CITY OF ALBUQUERQUE

April 25, 2013

**Re: Broadstone Santa Monica, 6401 Santa Monica NE,
Recreation Area and Office
Request for Permanent C.O. –Accepted
Engineer's Stamp dated: 4-10-12, (D18/D054)
Certification dated: 4-19-13**

CG1.2
GRADING AND DRAINAGE PLAN
NW QUADRANT

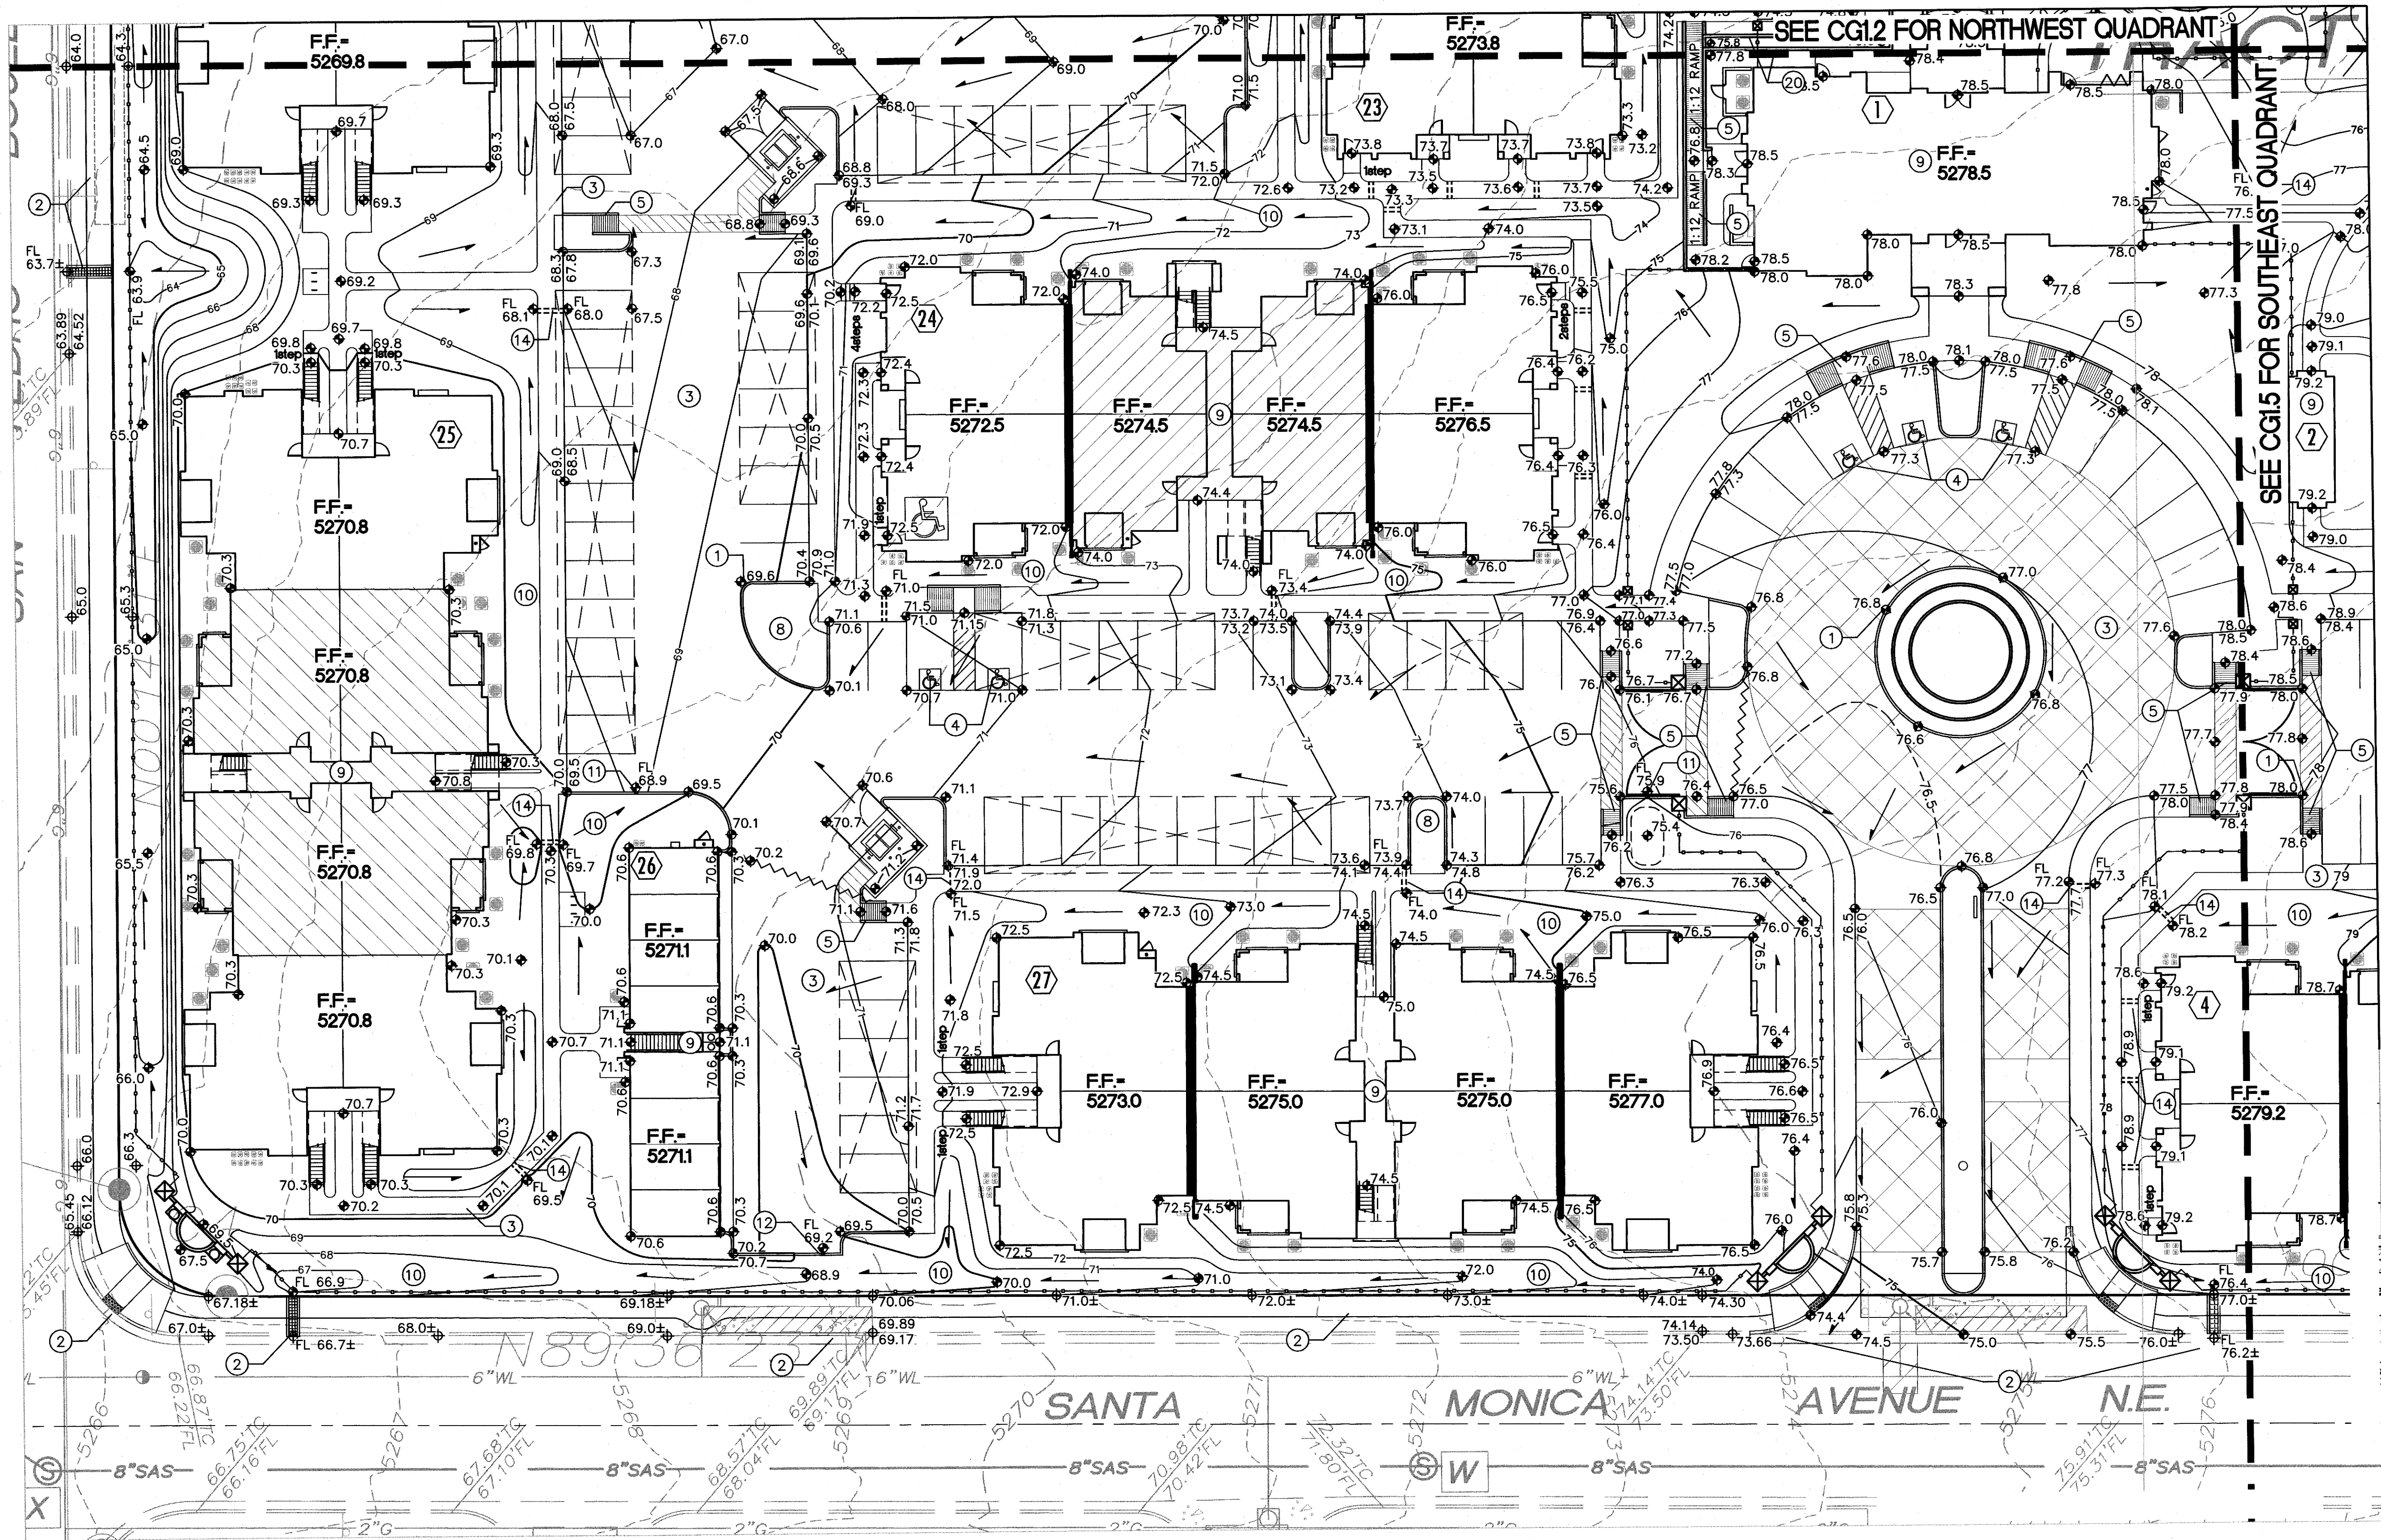
Before any other Certificate of Occupancies can be issued, the off site area needs to be certified. Also, in the NW corner of this site the rundown and pipe coming from the catch basin to the rundown need to be installed and working properly.
